**Mattamy Homes Richmond Official Plan Application
Response to City of Ottawa June 8, 2009 Technical Circulation & Additional Comments
February 22, 2010**

VILLAGE OF RICHMOND
PRELIMINARY CUT-FILL
GRADING OPTION 3A
CITY OF OTTAWA

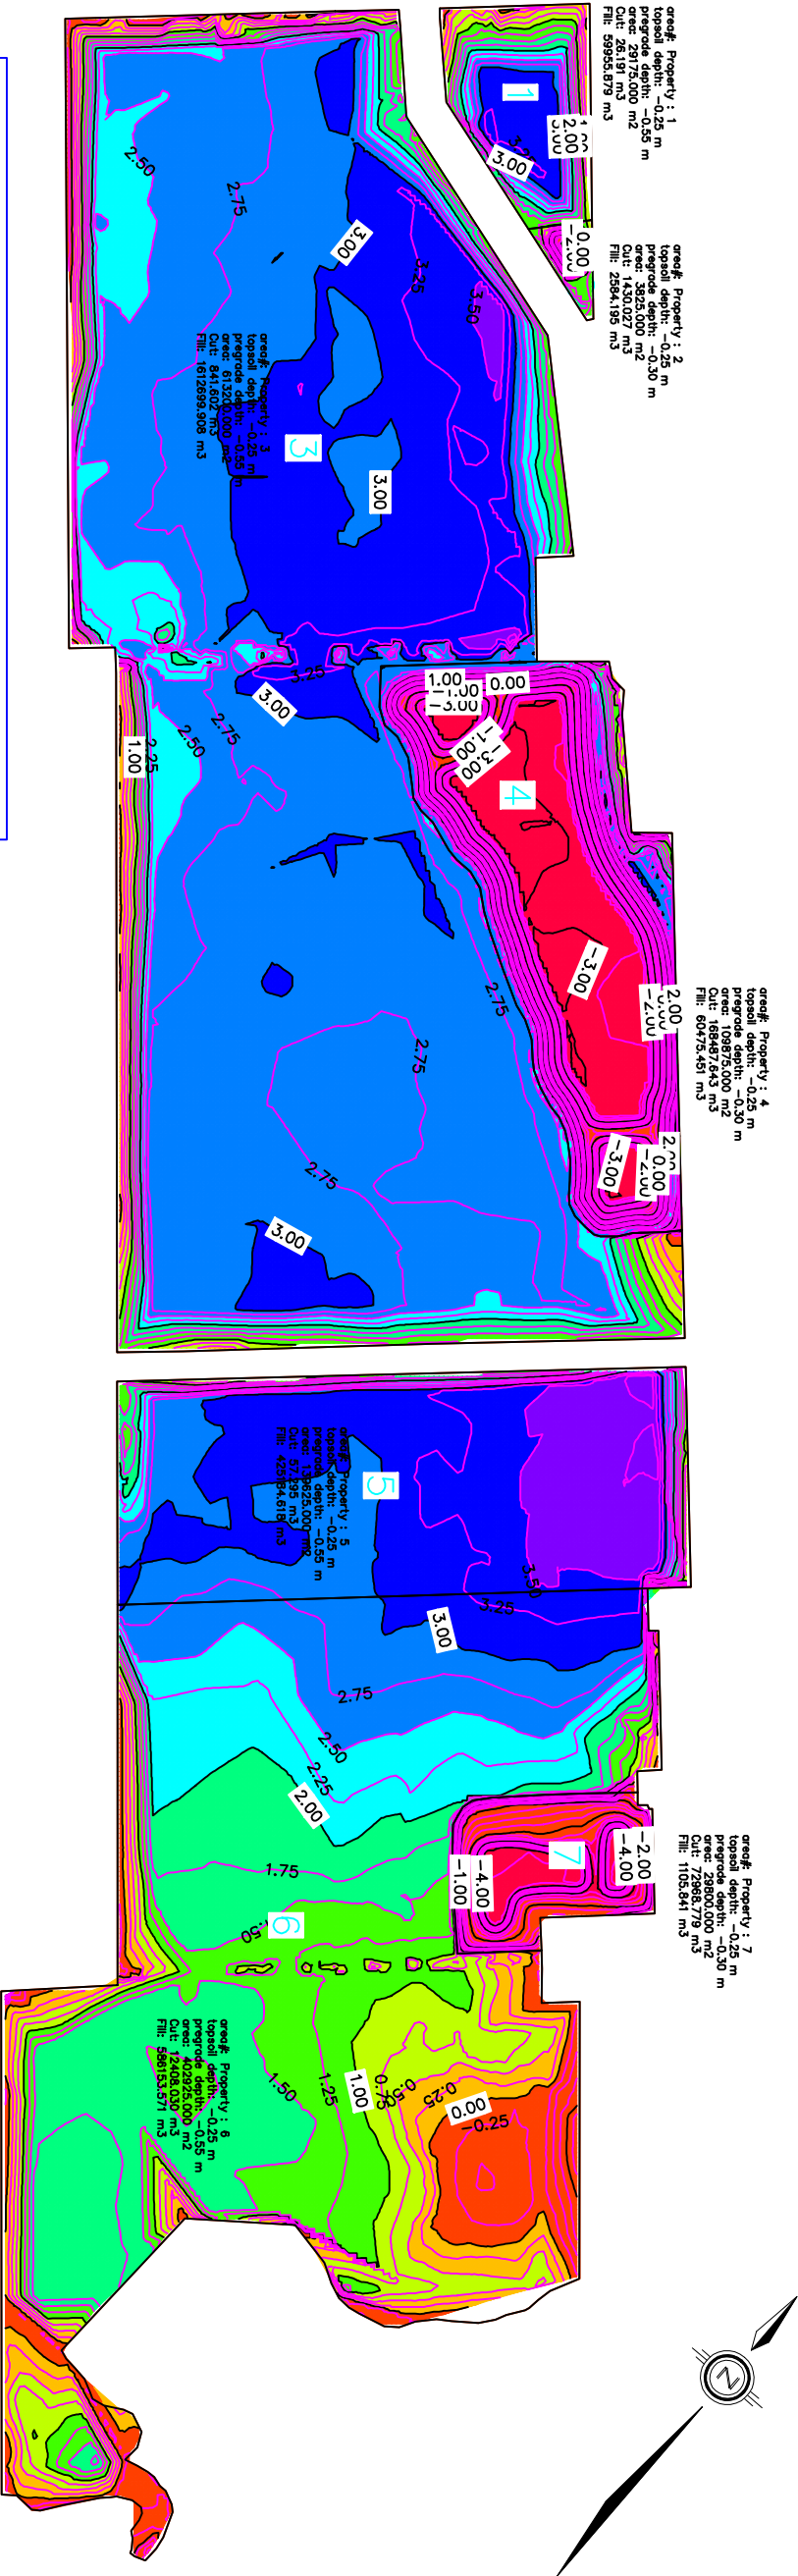
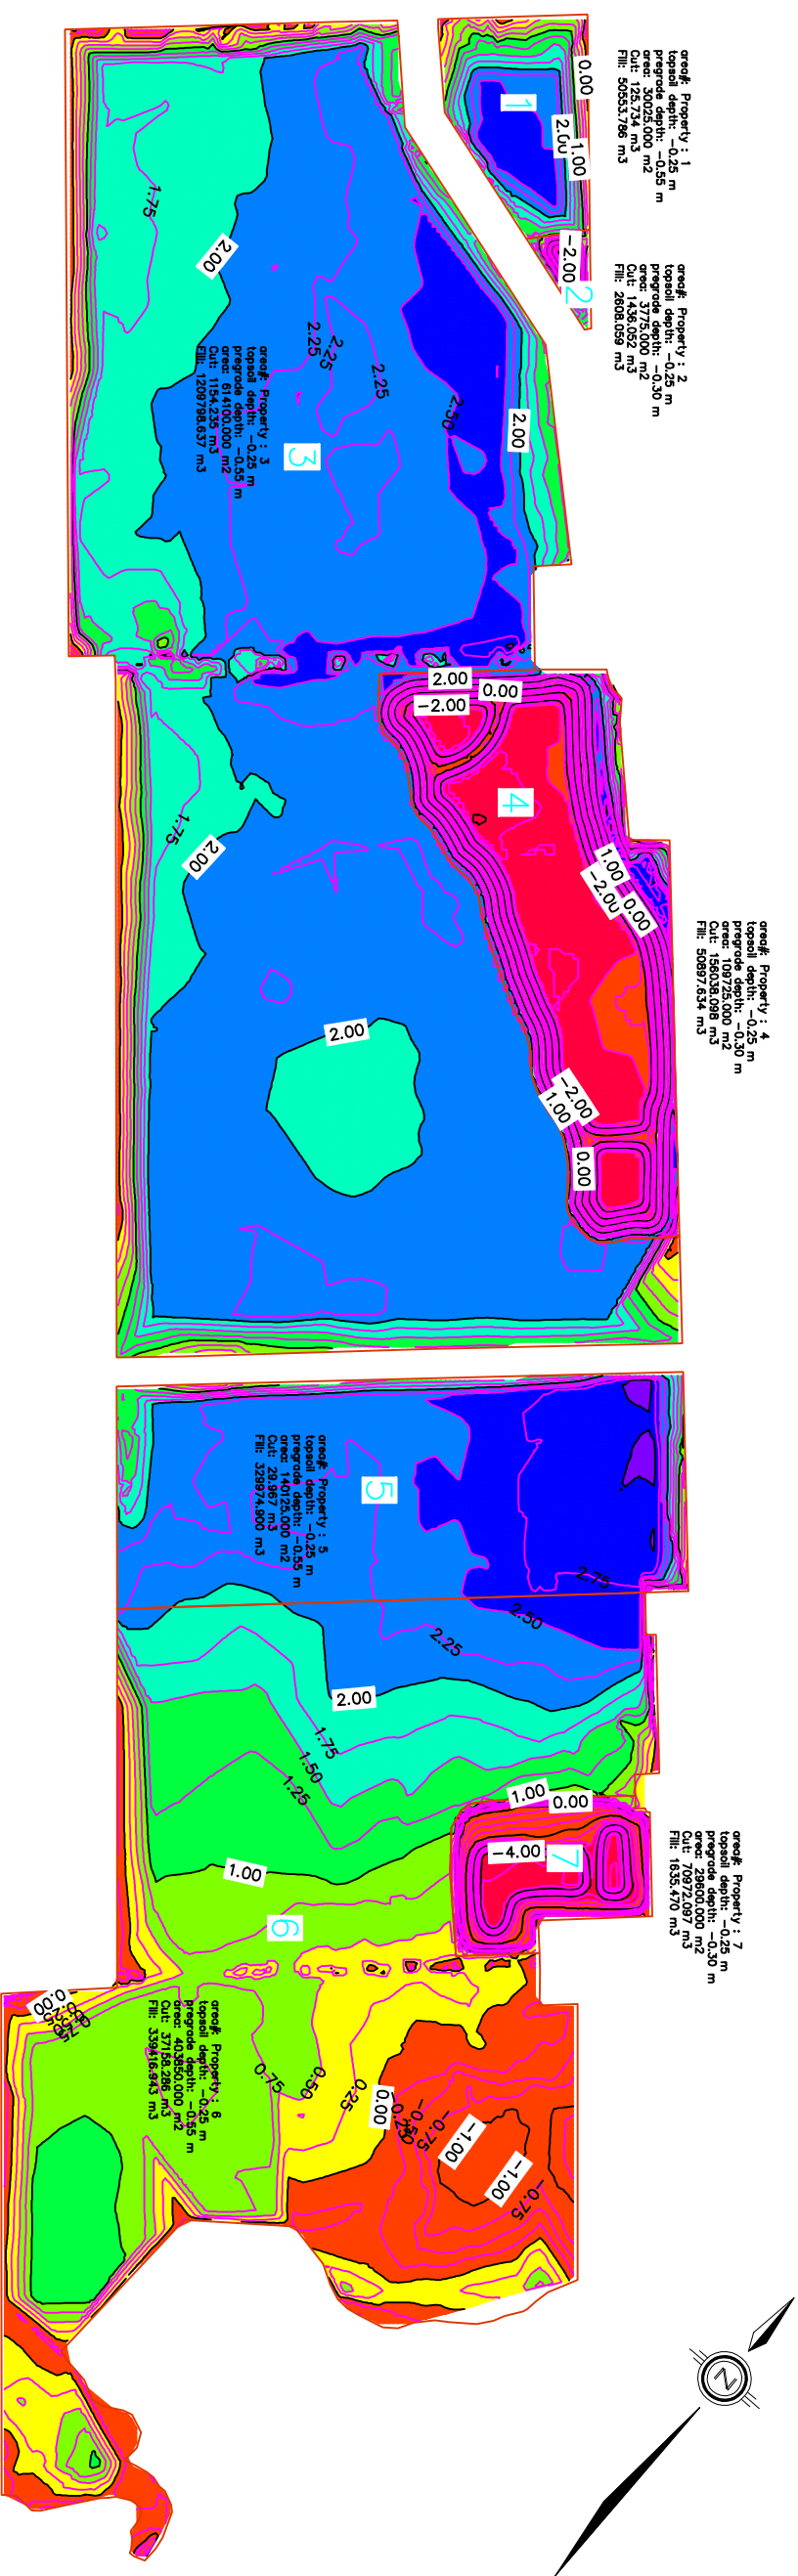
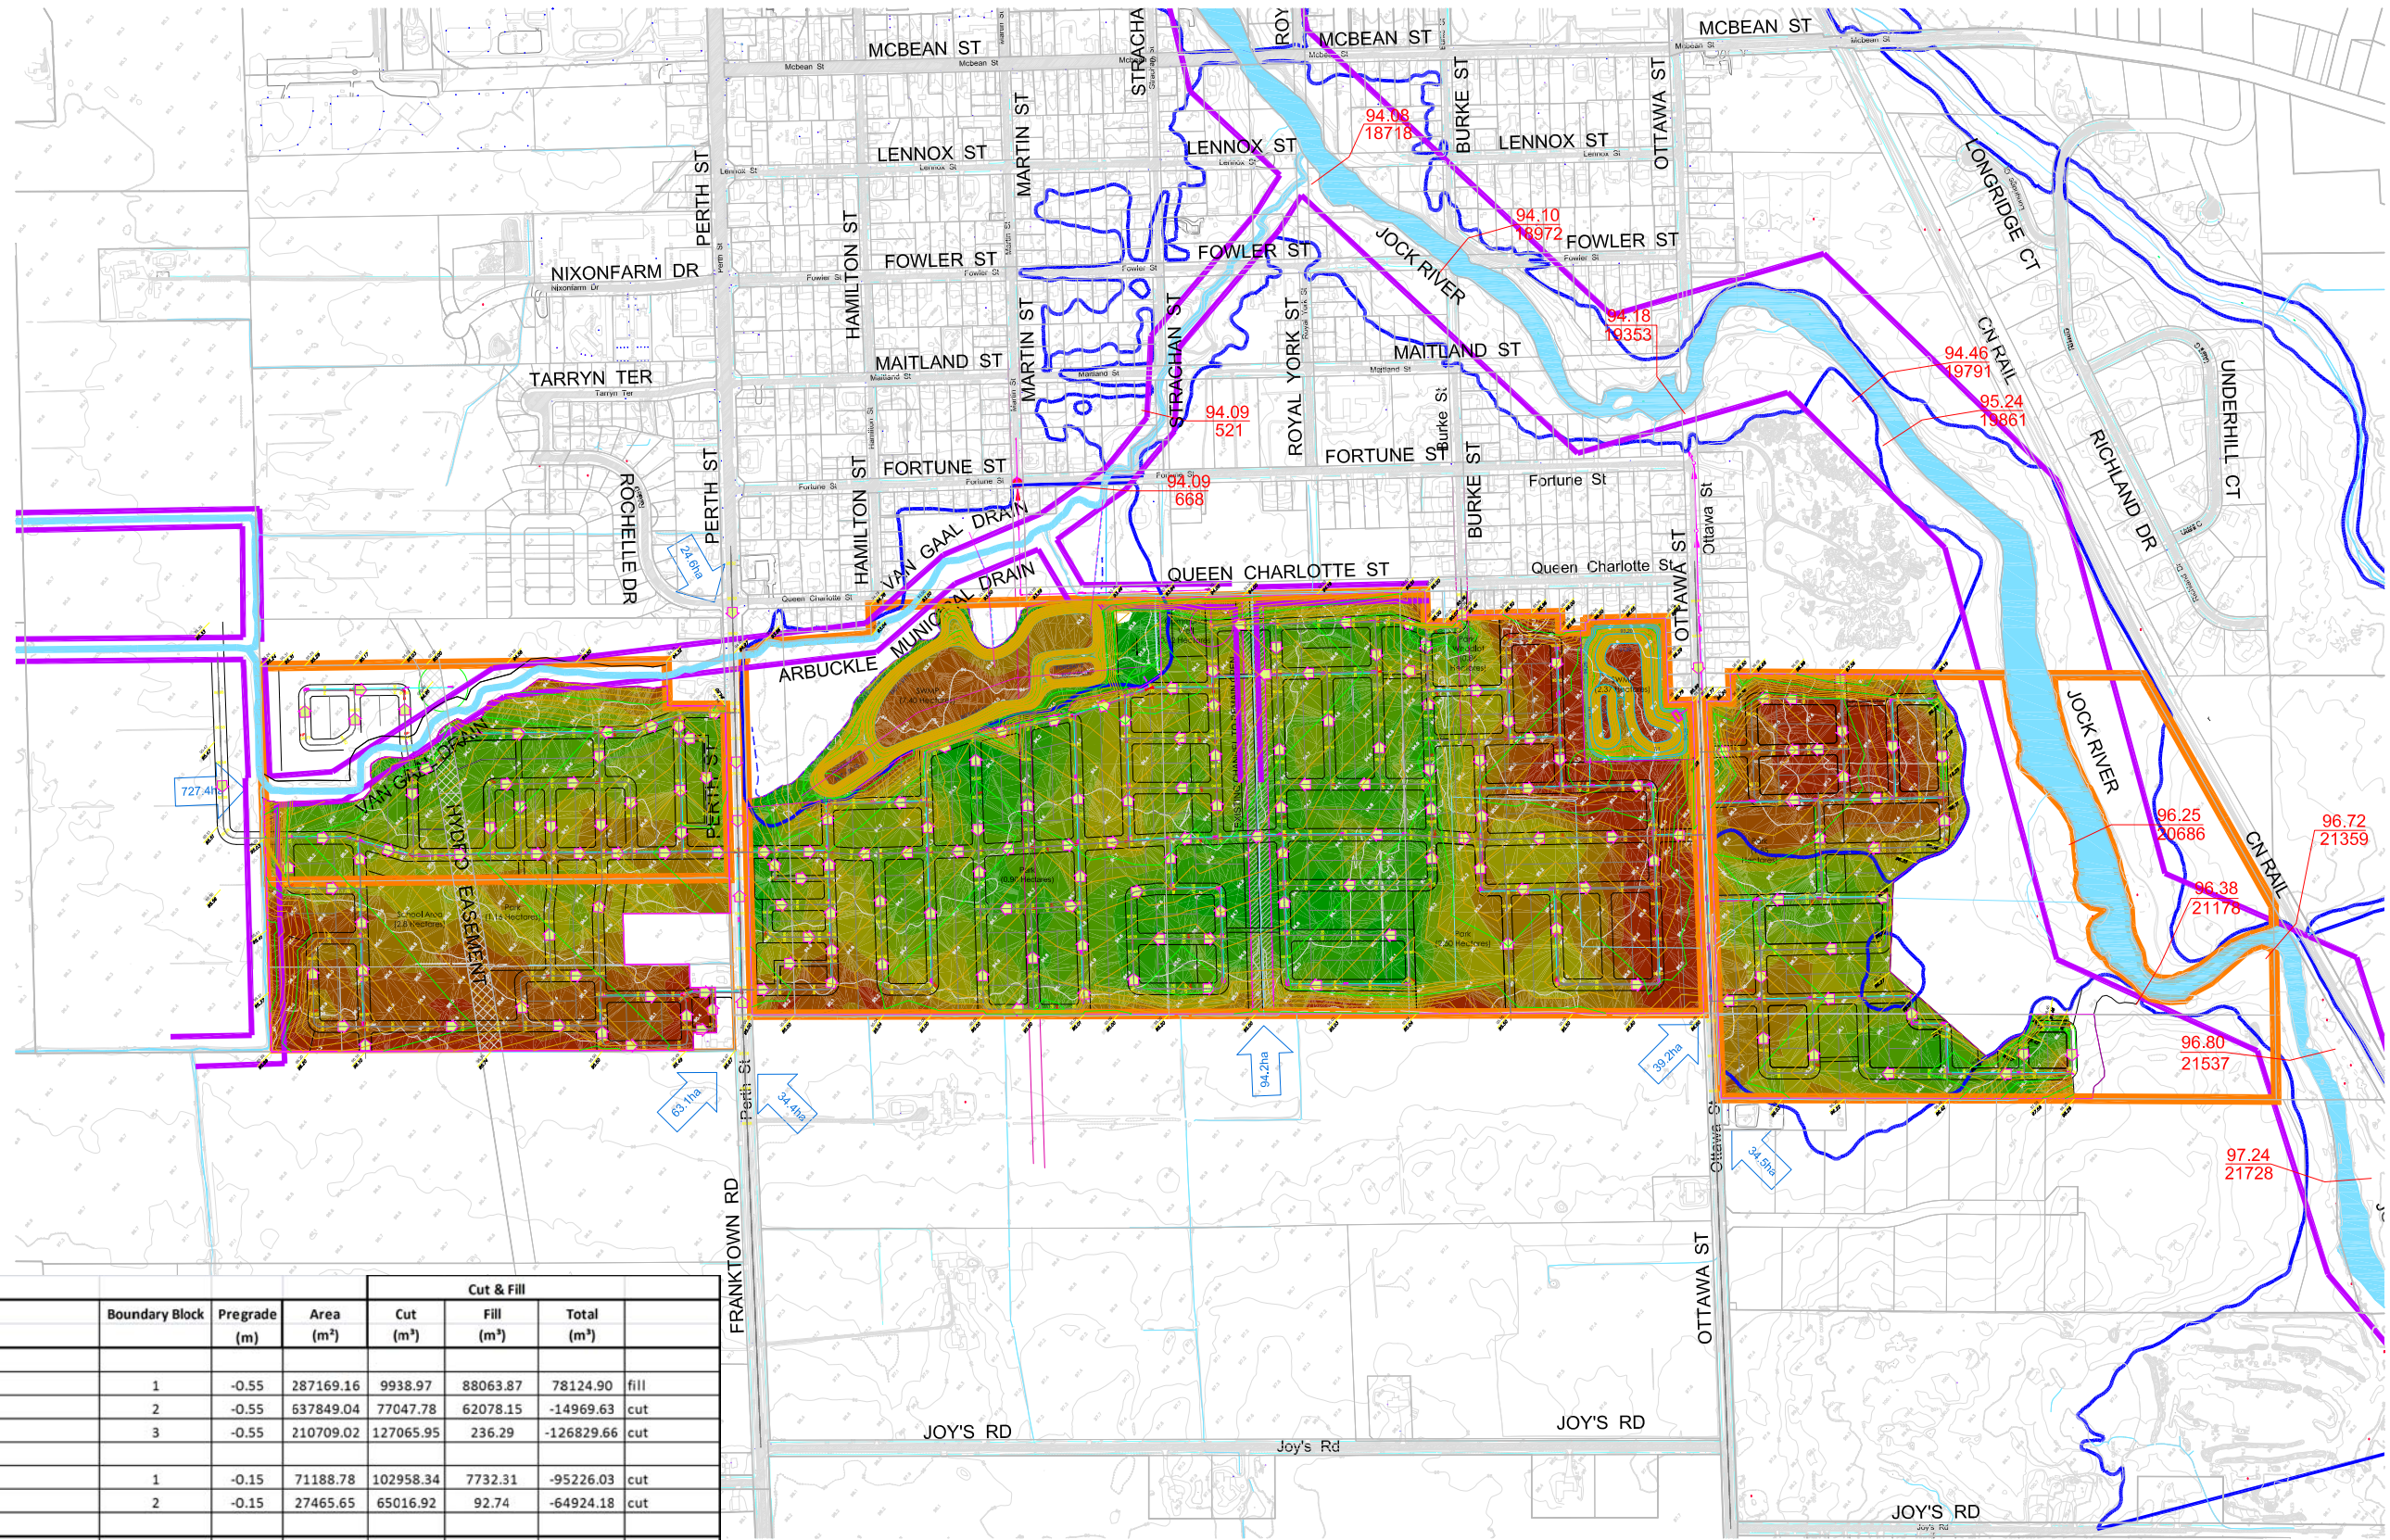
13.	<p>Fill Issues Your email states that at this stage only a high level assessment of the impacts of the fill can be conducted and that once the preliminary grading plan is confirmed further description on feasibility can be provided at the draft subdivision plan stage. Although further information may be provided at the subdivision plan stage, Section 4.3 does not adequately address the issue of the grading on woodlot (W3) and the feasibility of retaining the hedgerow and other vegetation. Natural Systems would like clarification on the potential impact of how the placement of the fill will be coordinated with the preservation of hedgerows, woodlots, and good quality trees and at the boundary of Mattamy's property.</p> <p>The Stormwater Management and Drainage Plan discuss the grading strategy (Page 69) and its impact on the boundary implications and maintaining hedgerows. This information should be integrated with the Natural Environment & Impact Assessment Study.</p>	City - Natural Systems Unit, July 2, 2009 Letter	July 10, 2009	<p>The placement of fill on the site plays a significant role on which trees and natural features can be incorporated into the development. However, the amount of fill required is dictated by the servicing requirements. Based on the recommended preliminary grading plan in the Stormwater Management and Drainage Plan, 1.2m of fill is required to service the site. Where fill is to be placed adjacent to trees and natural features, the following guidelines will apply and be added to the report:</p> <ul style="list-style-type: none"> • Grading and fill required for stormwater management and other servicing infrastructure will be minimized and where required, will be managed to protect the significant woodland, retained hedgerows and treed areas on and adjacent to the site. <p>Woodlot 3 is on an adjacent property. Fill/grading guidelines require that grading on Mattamy land respect existing grades on neighbouring properties. Further, there is a drainage ditch (Section 8 of the Moore Branch) that flows on the property line. The SWDMP uses that drainage ditch to convey overland flows (in large part from W3) to and through the Moore Branch.</p> <p>Hedgerow 3 will be highly modified. That section of the Moore Branch is to be regraded, then re-instated to retain a green aesthetic corridor through the development.</p> <p>City & RVCA September 23, 2009 Meeting: <i>Response satisfactory – add cross-section in report to show general tapering down of grading to match existing.</i></p> <p>City & RVCA October 7, 2009 meeting: <i>Grading guidelines contingent on sump pump strategy being approved. Finalize once preliminary grading plan approved.</i></p> <p>Mattamy February 19, 2010 response: <i>Sump pump strategy and preliminary grading plan being updated to reflect comments received January 29, 2010 and February 2, 2010 from city staff. Based on comments and meeting with city staff,</i></p>	Response found in Section 4.7, Grading of the Environmental Management Guidelines (pg 83).
